Our reference: ECM: 8965012
Contact: Gavin Cherry
Telephone: 4732 8125

3 March 2020

**Re: SSD 7348 - MOD 1, MOD 2, MOD 3 and SSD10397 for Stage 2
Development Works – Response to Amended Plans and Supporting
Information**

Title
GENERAL ARRANGEMENT MASTER PLAN

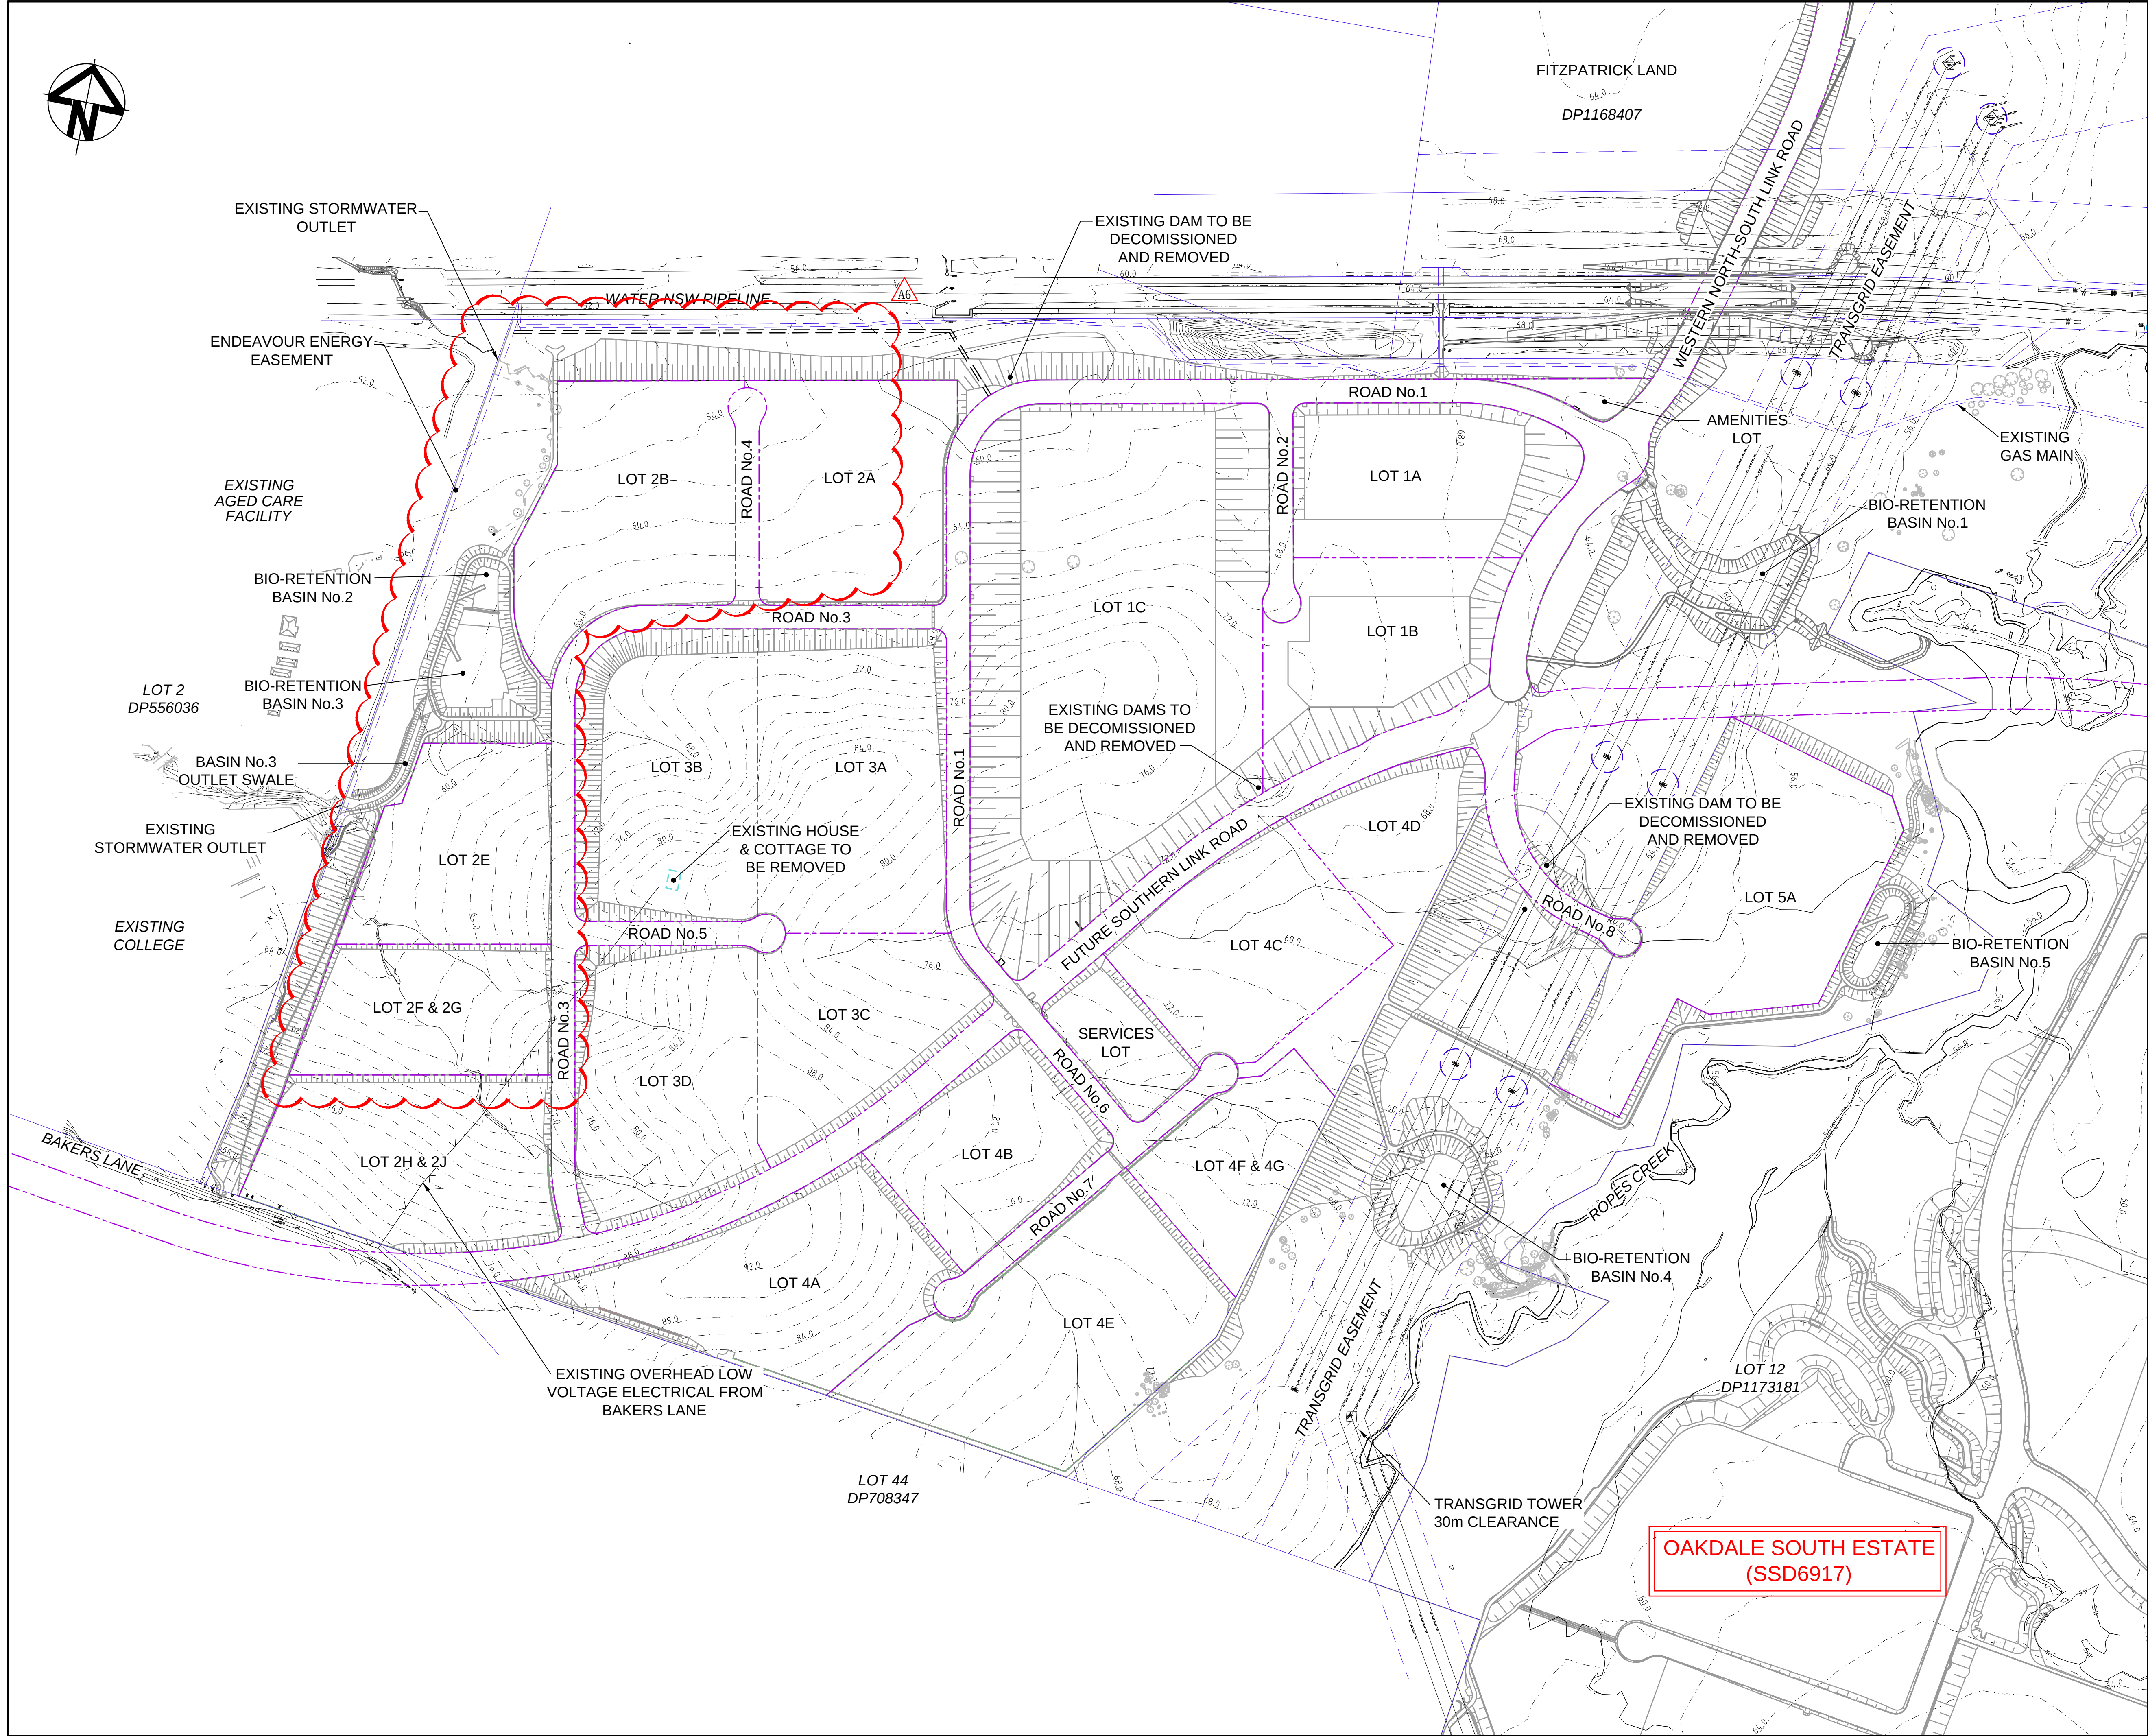
While the deletion / reduction of additional fill within Lots 2E – J within MOD 1 is supported, this change is not sufficient to resolve the comments raised by Council for the precinct as a whole. A separate plan exists, which does not rely on any works within MOD 3, and retains the allotment and road alignments as currently approved. This plan (amended on 19 February 2020) titled as the “General Arrangements Master Plan” (Issue A8) suggests finished ground levels within Lot 2A and 2B which are approximately 700mm above the indicated road level. This is assuming that the spot levels on the plan within the road reserve are the finished road levels and not natural topography in which case the finished road levels need to be reflected. While a level transition of 700mm is minor and manageable through landscape design treatments, the indicated finished ground level within Lot 3A and 3B is between 4 – 6m higher than the finished road level. This is an unsupportable interface outcome that appears to stem from the retention of Road 3 levels to achieve requirements to remove fill within Lots 2E-J. Lot 3D is also challenging as the resulting levels are now 6.3m below Road 3 or 6.6m above Road 3.

Notwithstanding the above, a separate revision to the General Arrangements Plan (Revision A11) has also been submitted as part of MOD1, which is not related to MOD1, but is reflective of the scope of works within MOD 3. This is not reliable and doesn’t form part of the MOD 1 application as it stands. It is however recommended that this plan (albeit amended) should be the replacement plan that ensures that these works and the spatial arrangement of the works is part of MOD 1, negating the need or reliance of any MOD 3 application. This separate and later revision provides a substantially different arrangement to that discussed above, with resulting level differences as follows:-

- Lot 2B (as amended) is 4.5m higher than the finished ground level of Road 3. This a poor outcome necessitating extensive retaining walls as presenting to the streetscape.
- Lots 2A (as amended) is 2.5m higher than the finished ground levels of Road 3, being a substantially worse interface outcome that than reflected within the existing SSD consent or that indicated by virtue of the MOD 1 amended earthworks as discussion above.
- Lot 2C, D & E with a finished ground level of 78.4 ranges from 1.2m below Road 3 (southern end) to 8.0m above Road 3 at the northern end. This is another example of a considerable worse outcome that reflected within the existing SSD consent or that indicated by virtue of the MOD 1 amended earthworks as discussion above.

Having regard to the earthworks concerns above, the MOD 1 General Arrangements Plan (not reliant on MOD 2 or MOD 3 spatial arrangement changes will result in a level difference of 5.5m between Lot 1C and Road 1. This is an excessive and poor internal interface outcome noting that Lot 3A and 3V by virtue of created flat developable areas,

SECTION 1
1: 1000V
1: 2000H

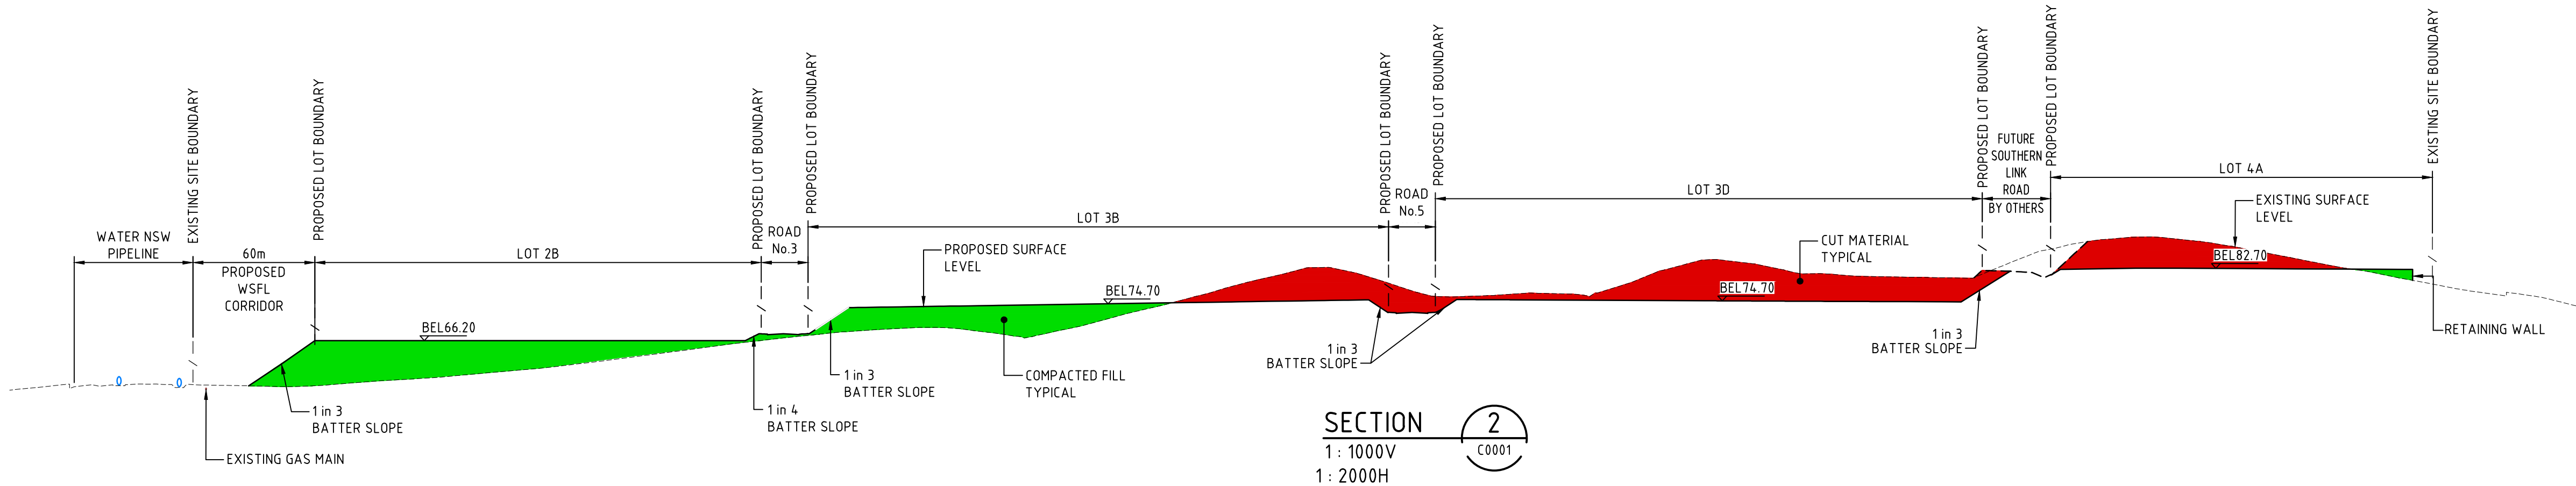
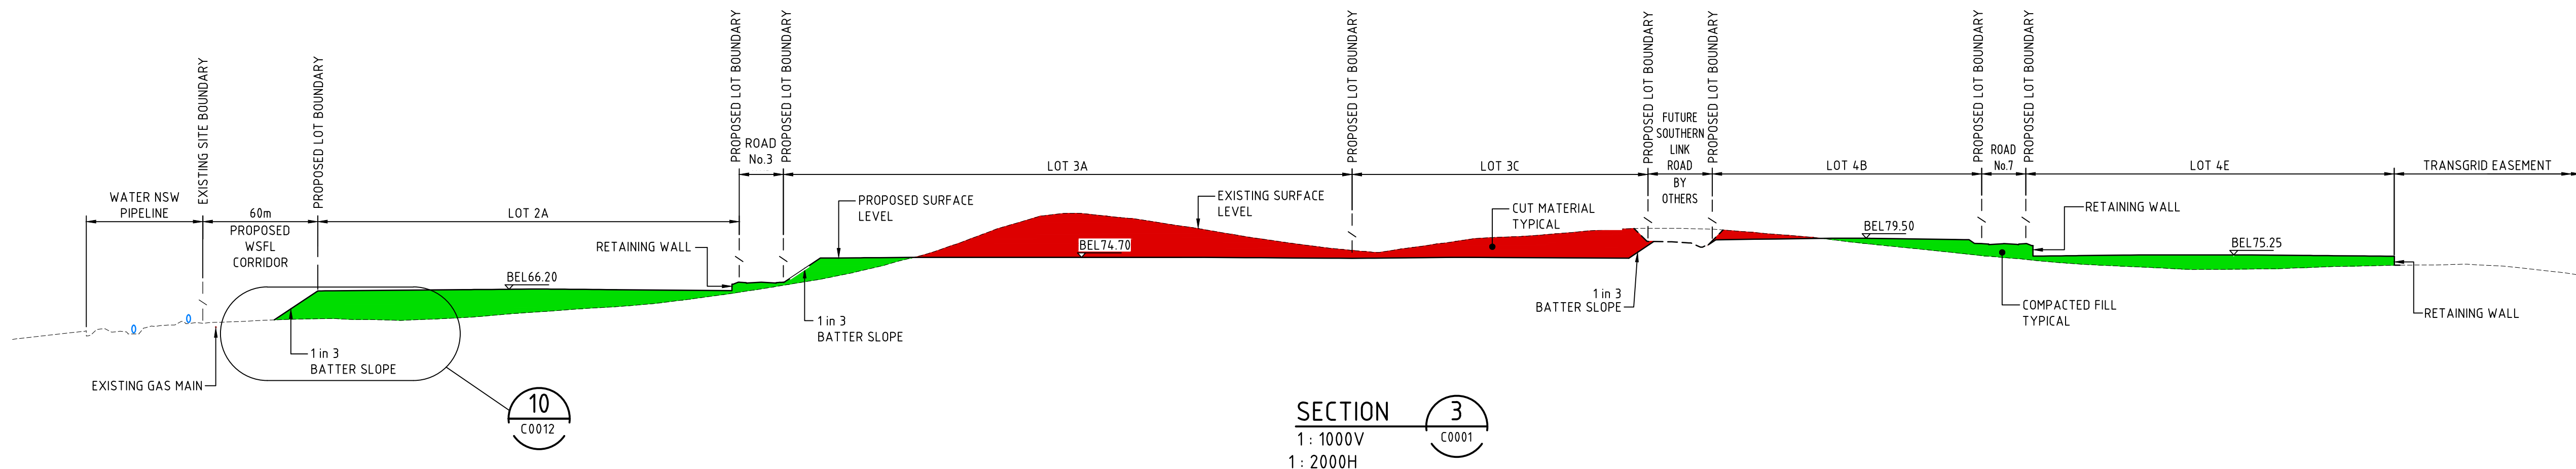
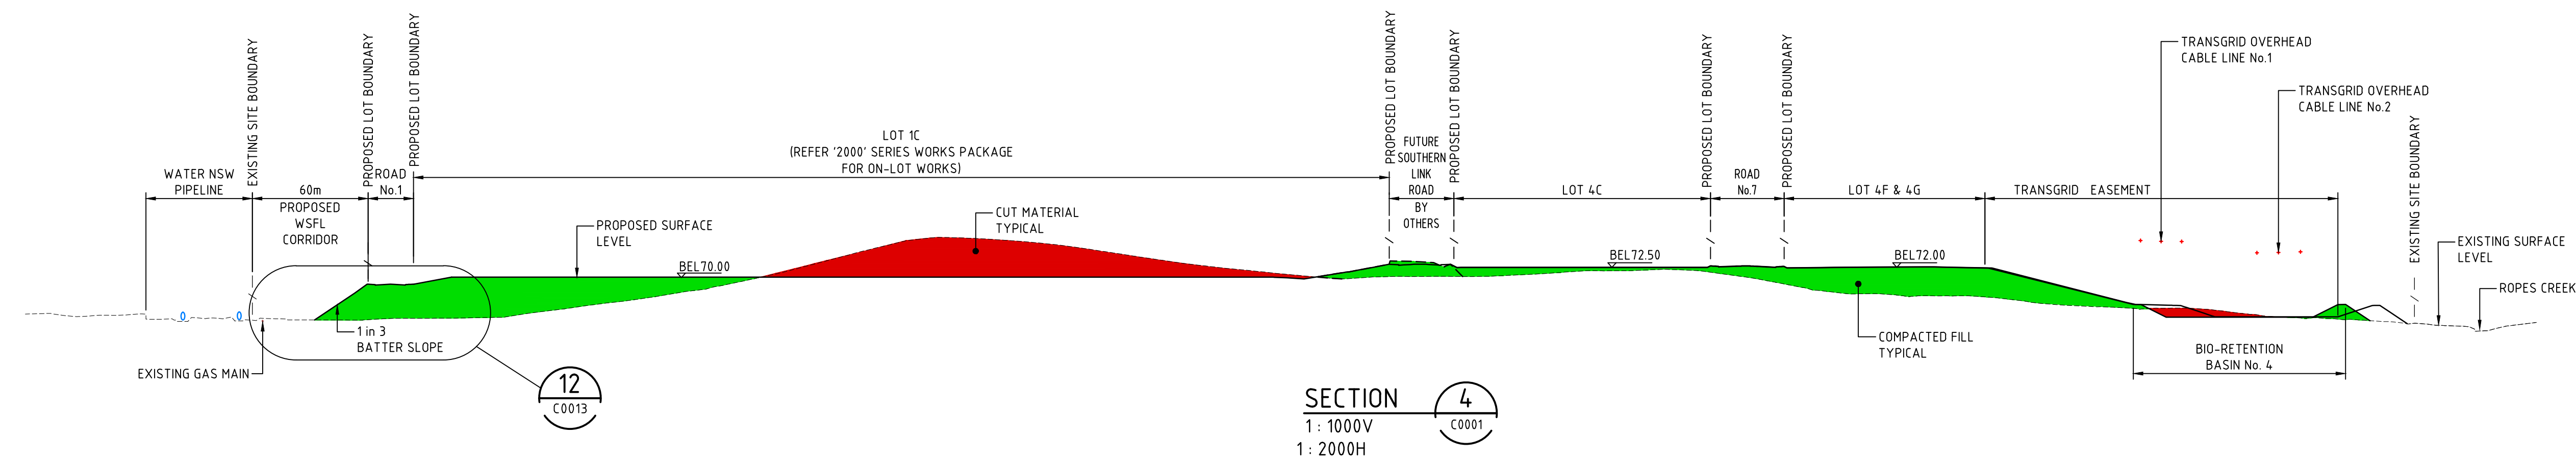
Amended plans and supporting cross sectional drawings submitted by the Applicant for MOD 1 include references and reliance to works and a building form that is not subject of MOD 1, or MOD 3 and appears to suggest an intention for a future building form. Plan revisions notes on the amended documentation suggest they exist for information only, but there is still a resulting suggestion that the interface treatments resulting from the MOD 1 works are intended to be resolved / managed through the MOD 3 or future separate applications which is not acceptable.

It is evident from the cross sectional drawings (with MOD 3 notations) that Road 3 is largely a result of filling works, and the resulting interface outcomes stem from the creation of flat developable allotments that do not respond to the topography of the site and the need to step the building form and spatial arrangement of future development to respond to that topography. The proposed finished levels in fact do the opposite, with little to nil excavation within the allotments to balance the cut and fill ratios through the development. This was the key concern outlined within Council’s previous comments and the amendments undertaken have not sufficiently acknowledged this need, or appropriately responded to this need.
